Yorkshire Green Energy Enablement (GREEN) Project

**Document 8.20 Applicant's Comments on Written Representations
and other Interested Parties' Deadline 2 Submissions**

**Final Issue A
May 2023**

Planning Inspectorate Reference: EN020024

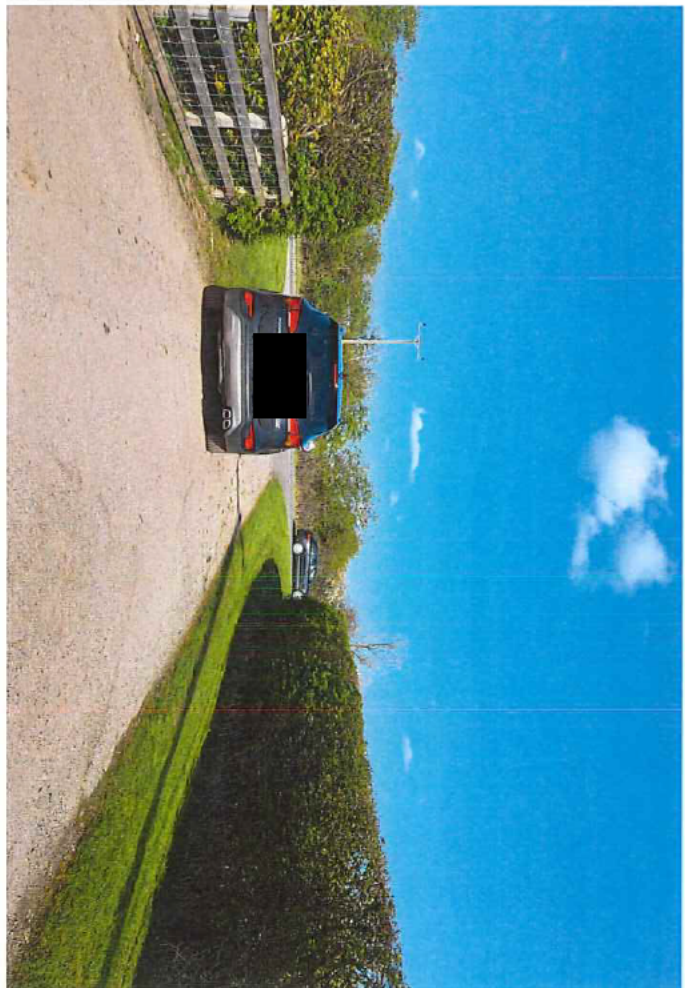
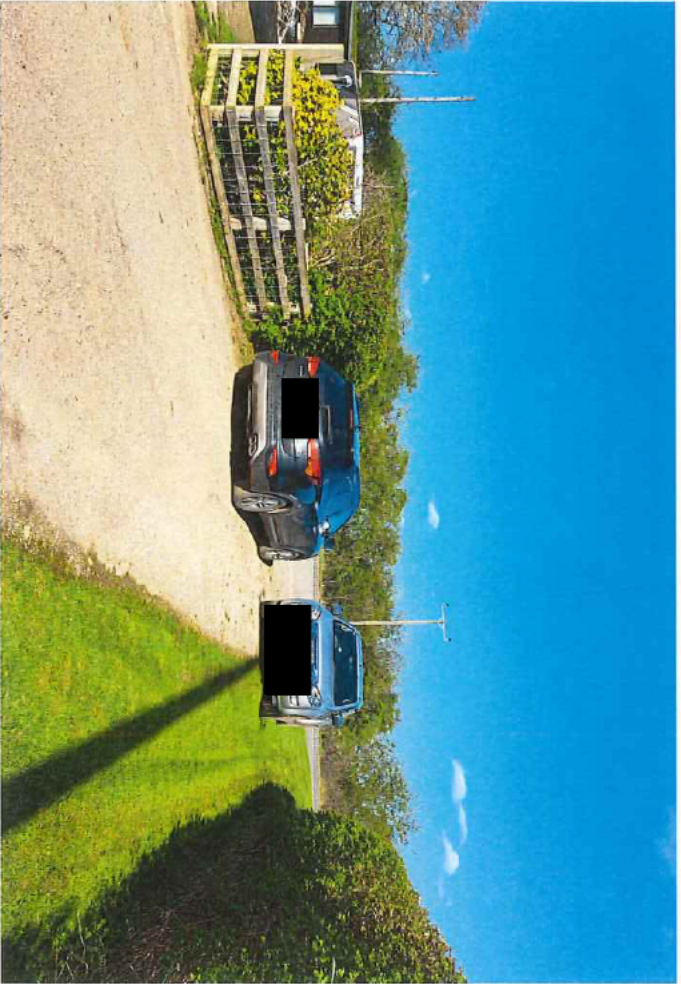
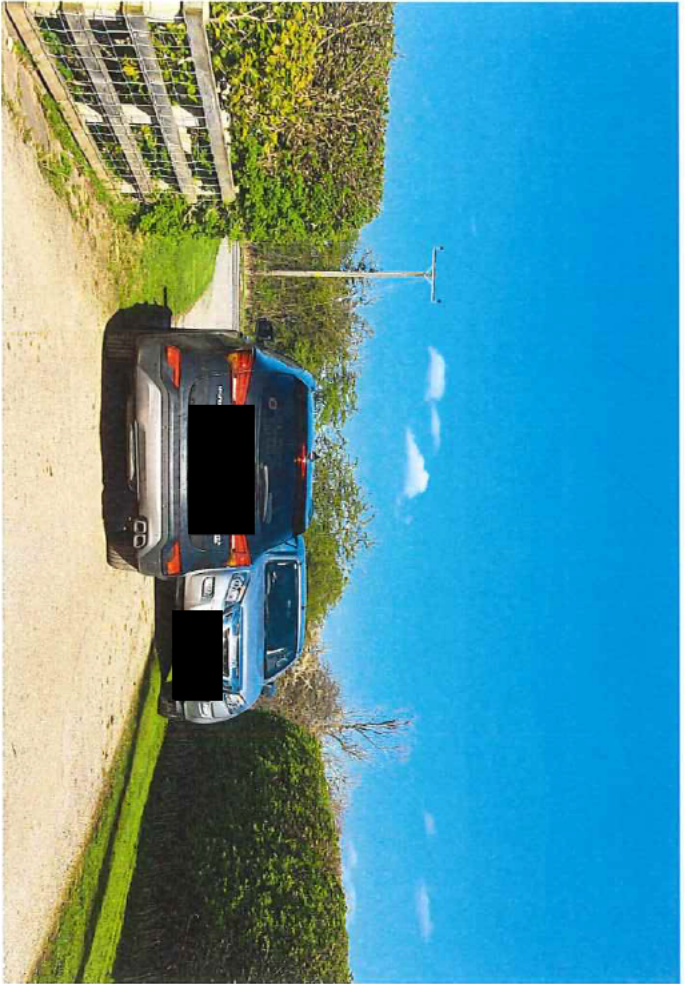
Reference	Topic	Applicant’s Response
2	Access to SP005	<p>National Grid notes the comments on proposed access to pylon SP005 and the recommended alternative access put forward on the supporting plans.</p> <p>The access proposal allows for a 40m wide bellmouth and a 12m wide access from the A19 to pylon SP005, which is designed to facilitate crane access during pylon erection (as shown on Access, Rights of Way and Public Rights of Navigation Plan Section B (Document 2.7.2(B)) [REP2-006]).</p> <p>Due to the size requirement of the access, it is necessary to dismantle and underground the 11kV overhead wires attached to the existing wood pole which is located in close proximity to the access entrance. This will need to be undertaken prior to overhead line construction works.</p> <p>This access has been proposed as it utilises an existing bellmouth and an existing track which is proposed for widening/improvements and requires only a small section of new stone access in the field to the north. Any works to the existing access and bellmouth, and the proposed new section of stone access to SP005 are temporary only and will be reinstated to their current, pre-construction conditions following completion of the construction works.</p>

Reference	Topic	Applicant's Response
9	Alternative access for construction	<p>National Grid notes the comments and plan provided for the alternative route proposed by Mrs Pamela Husband, Ms Gill Eves and Mr Paul Bulmer. This alternative access would require a section of new, temporary stone access from pylon SP004 to SP005, and an additional temporary bridge structure over Hurns Gutter.</p> <p>Due to the short timescales between Deadline 2 and Deadline 3, and the nature of the assessment works required to inform the response, it is not possible to provide more detail on this at Deadline 3. National Grid will provide a more detailed response on the suggested alternative at Deadline 4 of the Examination.</p>
10	Alternative access for maintenance	<p>National Grid notes the comments and plan provided for the alternative route for future maintenance by Mrs Pamela Husband, Ms Gill Eves and Mr Paul Bulmer. The works would involve installing and maintaining a new permanent bridge structure over Hurns Gutter and National Grid are not proposing to install any permanent bridges on the Project.</p> <p>The works required for future maintenance are as described in ES Chapter 3: Description of the project, section 3.9 (Document 5.2.3) [APP-075]. The overhead line will be subject to annual maintenance, consisting of a line walk which is typically a person in a van to access the pylon. Future reconductoring works typically only occur once every 40 years.</p> <p>Due to the very low yearly maintenance vehicle movements, National Grid do not consider that a new permanent bridge is required, justified or necessary for future maintenance and propose to utilise the existing access track.</p>
